Bramford to Twinstead Reinforcement

Document 6.6: Scoping Opinion

Proposed Bramford to Twinstead Overhead Line Project

Case Reference: EN020002

**FIGURE 4.1**

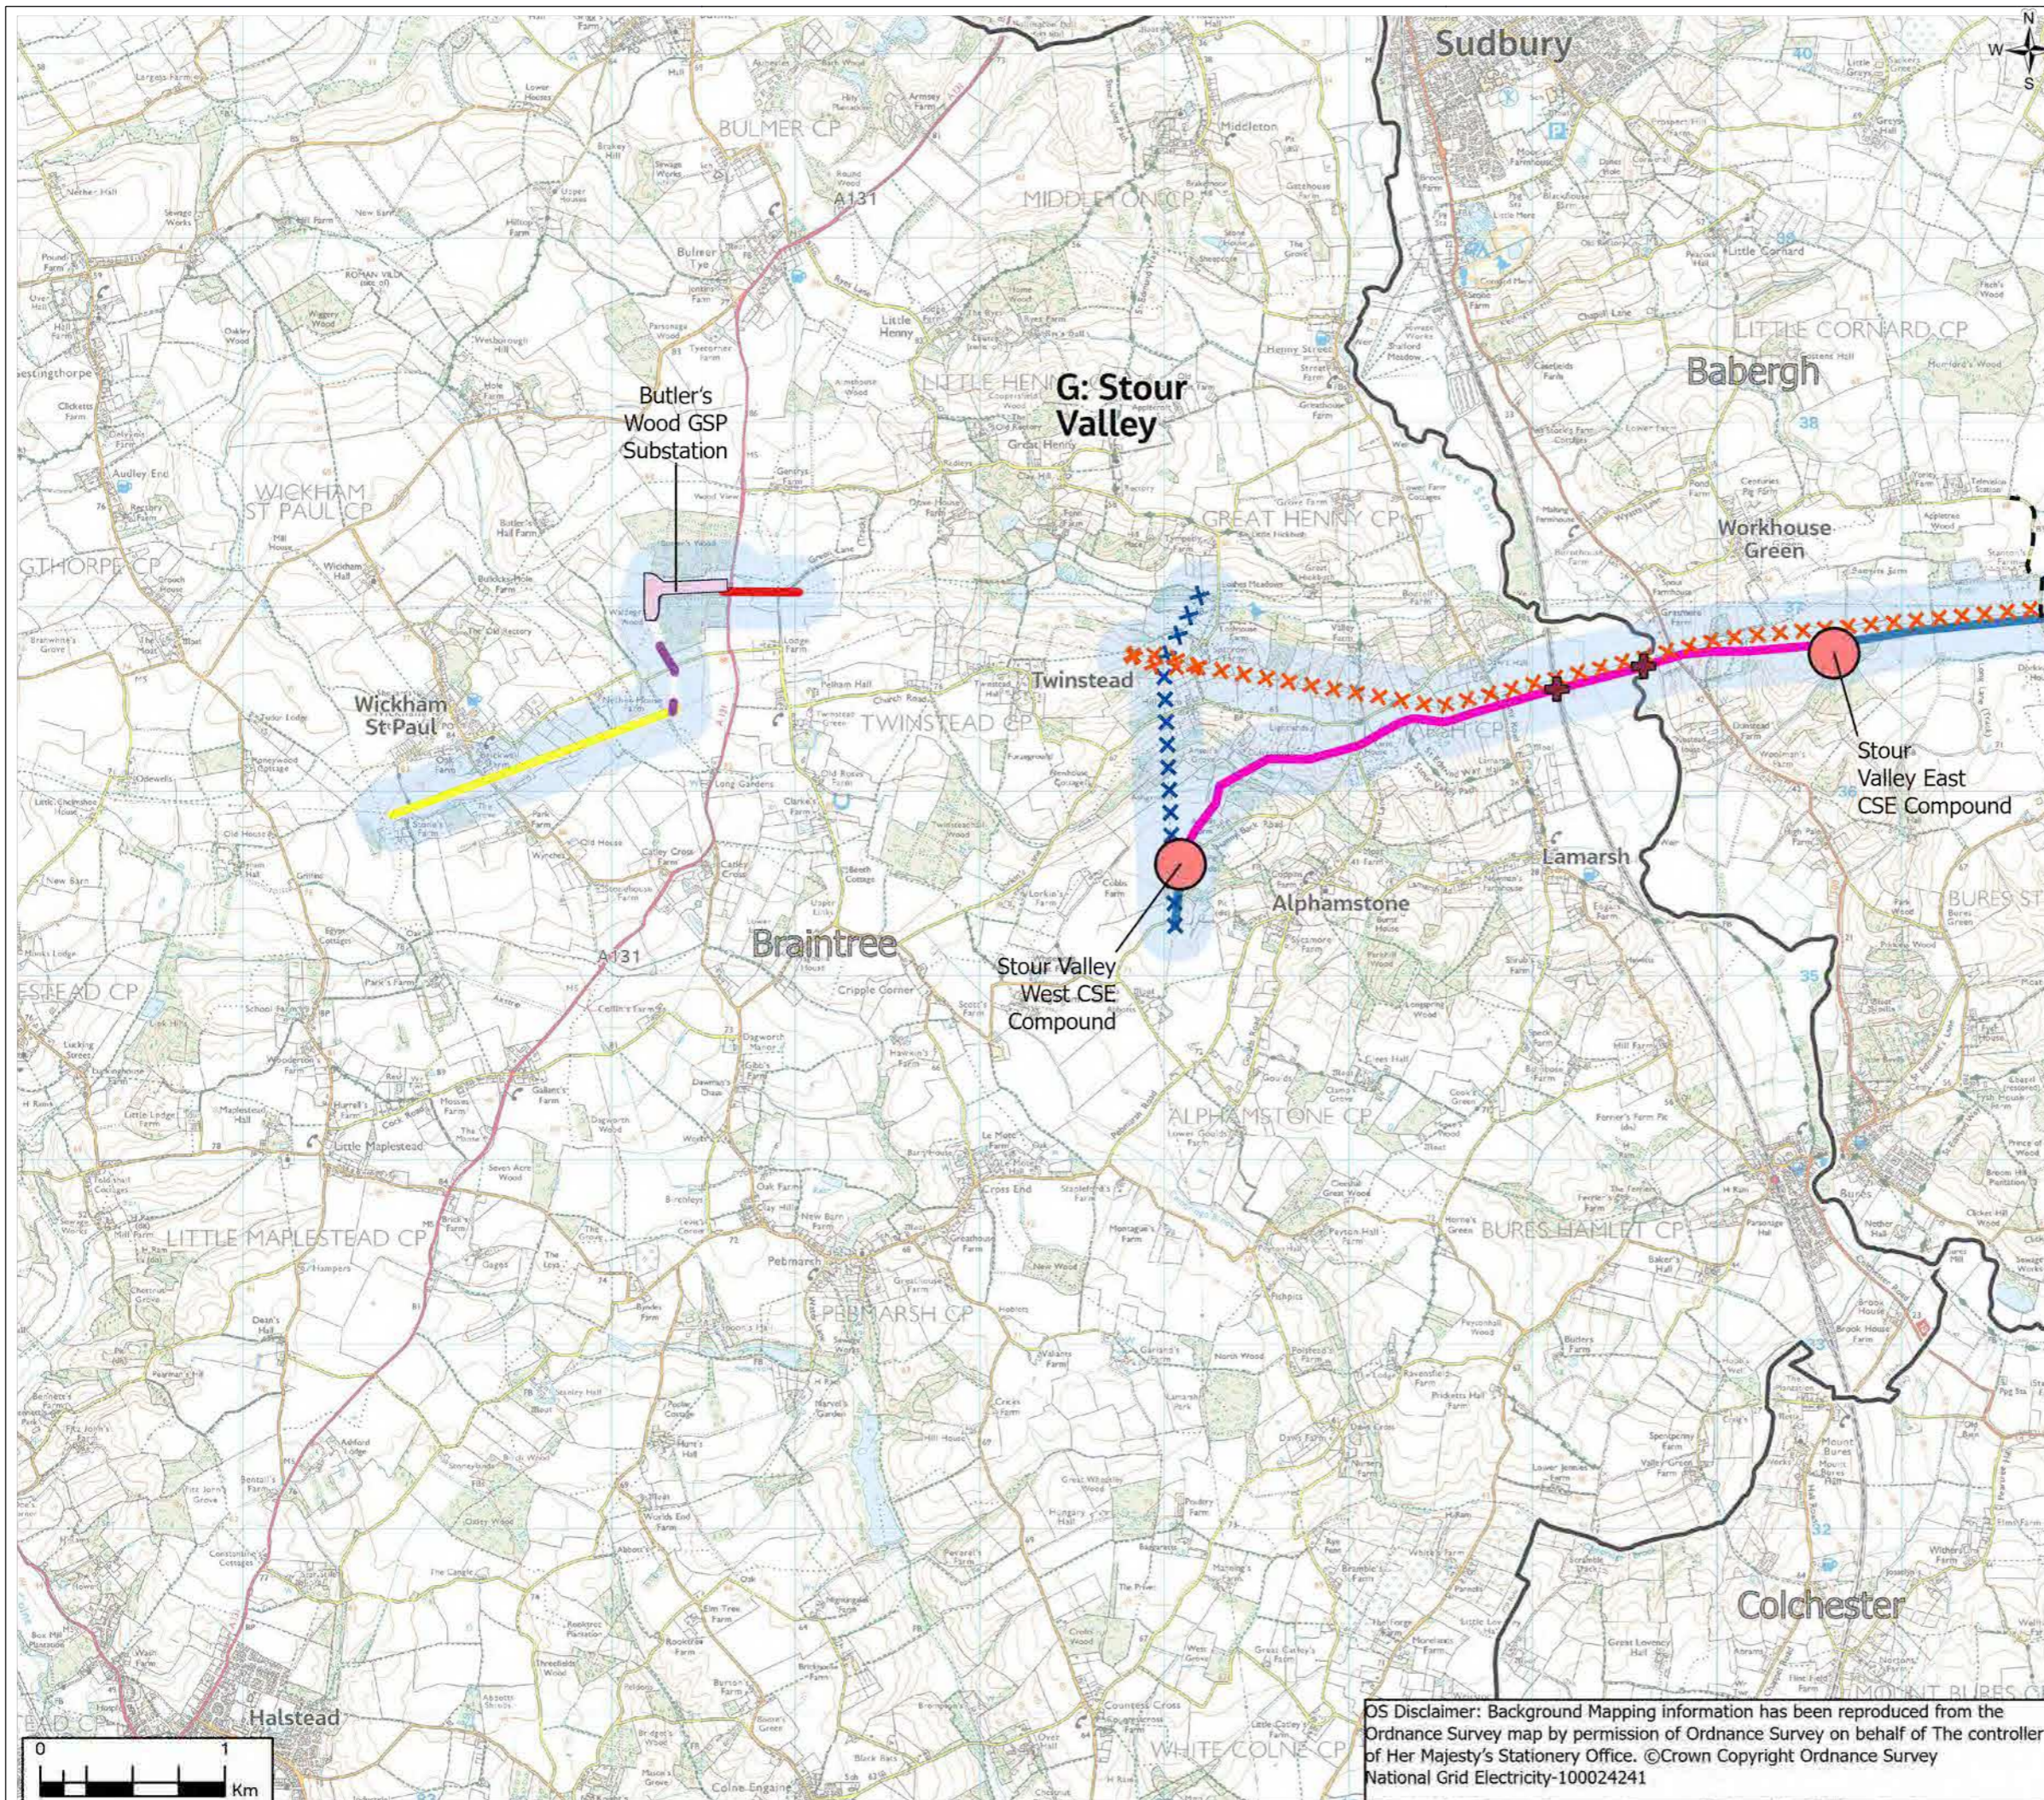
2.2.2 The Proposed Development involves construction and operation of a 400 kilovolt (kV) electricity transmission reinforcement between Bramford substation in Suffolk and Twinstead Tee in Essex following removal of existing 400kV and 132kV infrastructure, as illustrated on a series of plans presented at Figure 4.1 (Volume 3) (AAA_B2B_04_Proposed Development).

- 2.3.4 The Inspectorate notes that the final alignment of the proposed OHL is still to be confirmed and that there are options under consideration for routeing of the proposed underground cable at Dollops Wood and the siting of the CSEC at Dedham Vale East. The Applicant should make effort to fix the siting of each component and reduce uncertainty; where this is not possible, the Applicant

should ensure that the ES assesses a worst-case scenario adopting a parameters based approach.
